The following final drainage report details the hydrologic assessment conducted for the proposed Pike Solar Project (the “Project”). The Project will be a 175 megawatt (MW) photovoltaic solar facility and up to 75 MW battery energy storage system consisting of photovoltaic modules aligned in arrays Wording removed single-axis tracking system. Although the property boundary area encompasses a total of 4,050 acres in El Paso County, Colorado, the Project will only be constructed on approximately 1,240 acres of the property.

PIKE SOLAR
 EL PASO COUNTY, COLORADO
 CONSTRUCTION DOCUMENTS
 FLOOD PLAN CROSSINGS #1 P&P

FLOODPLAIN CROSSING #1 (43+00-54+00)

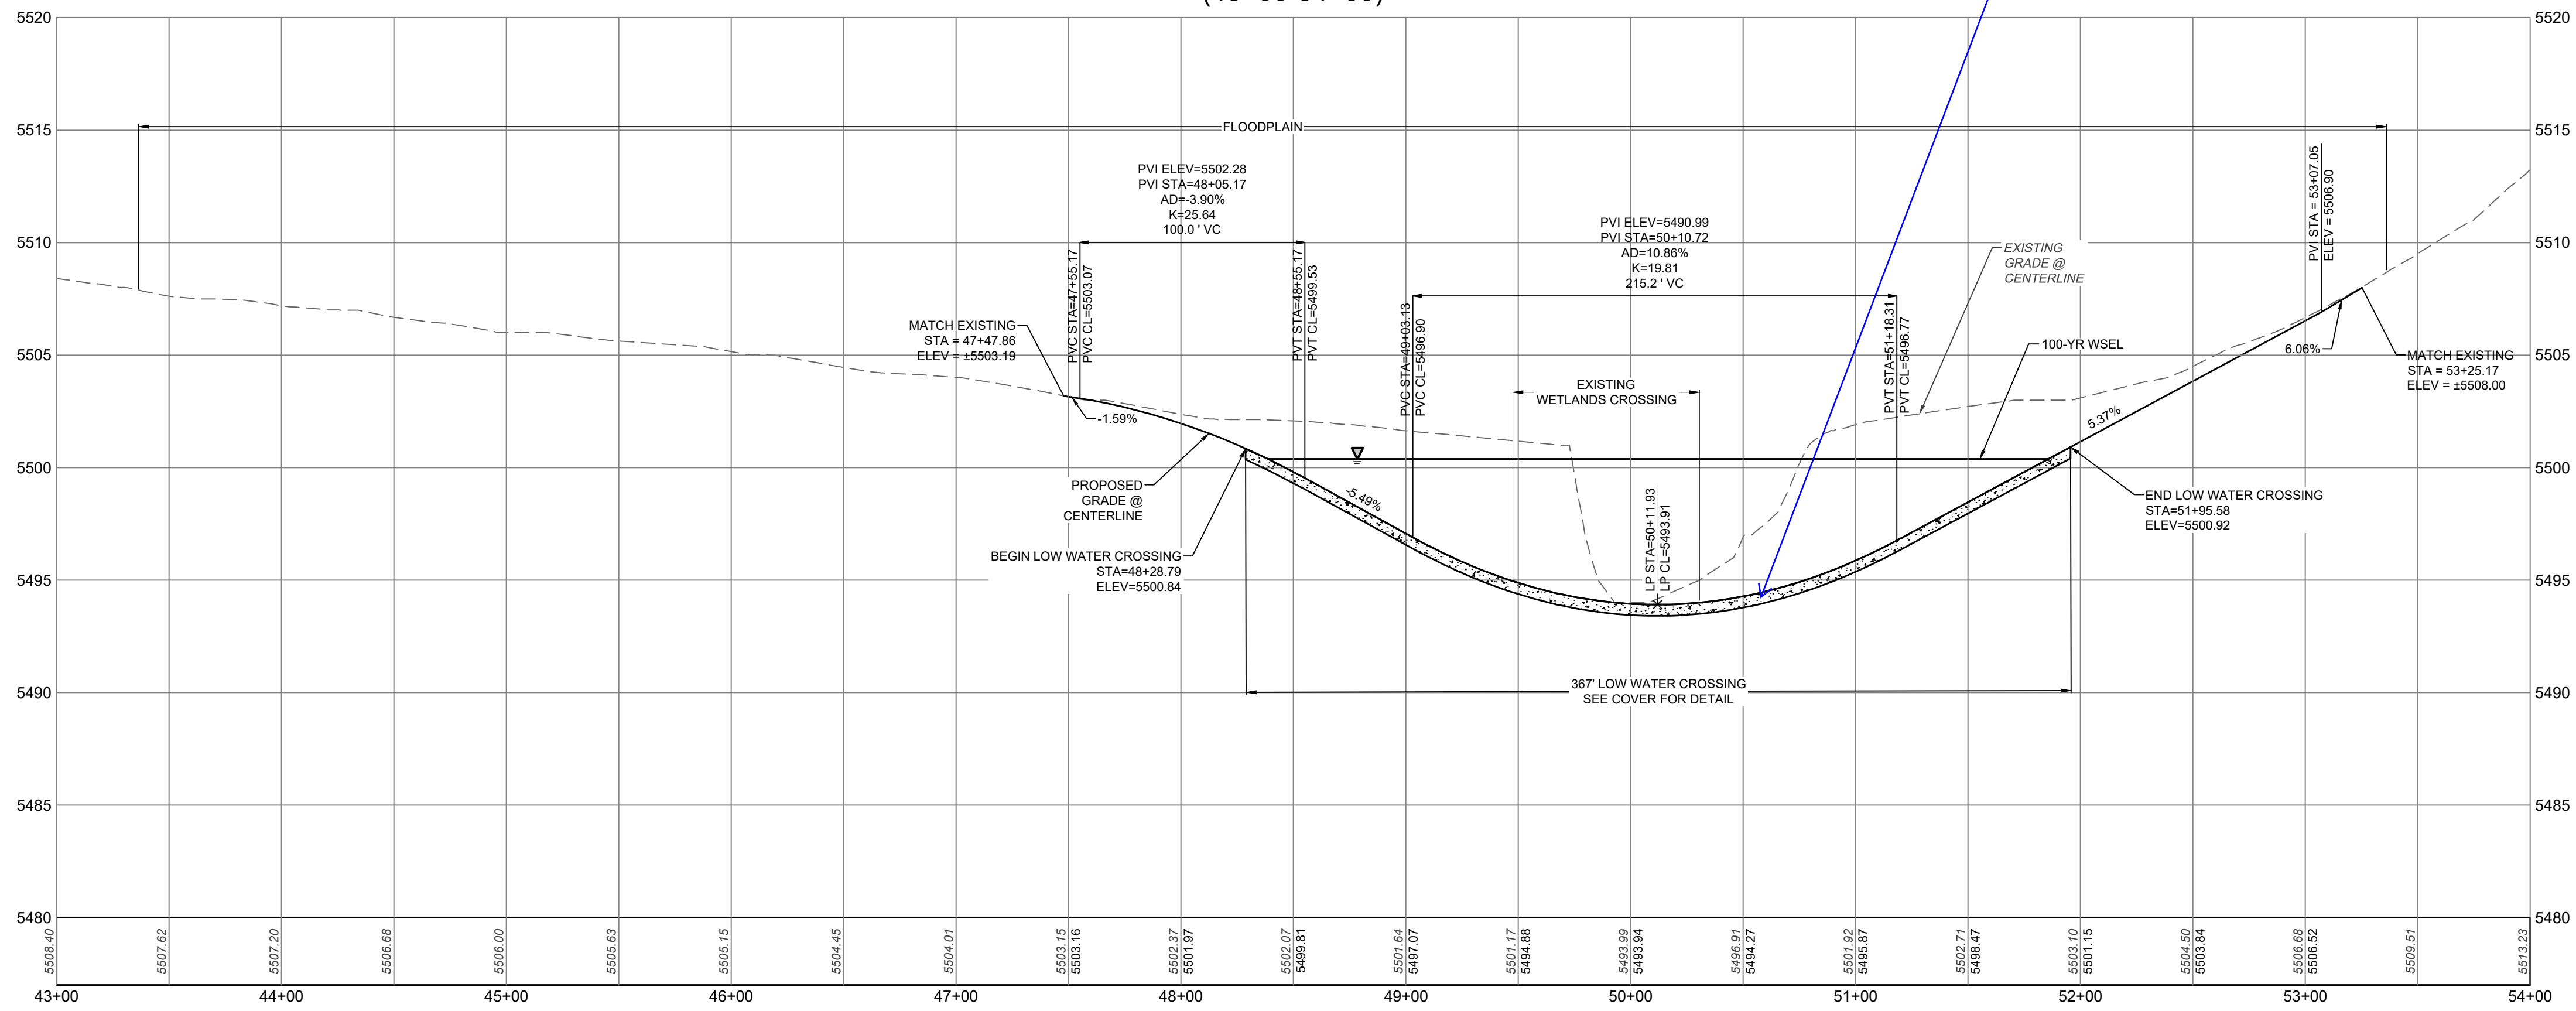
Label proposed material or provide cover sheet or detail on this sheet

Detail added to floodplain crossing sheets
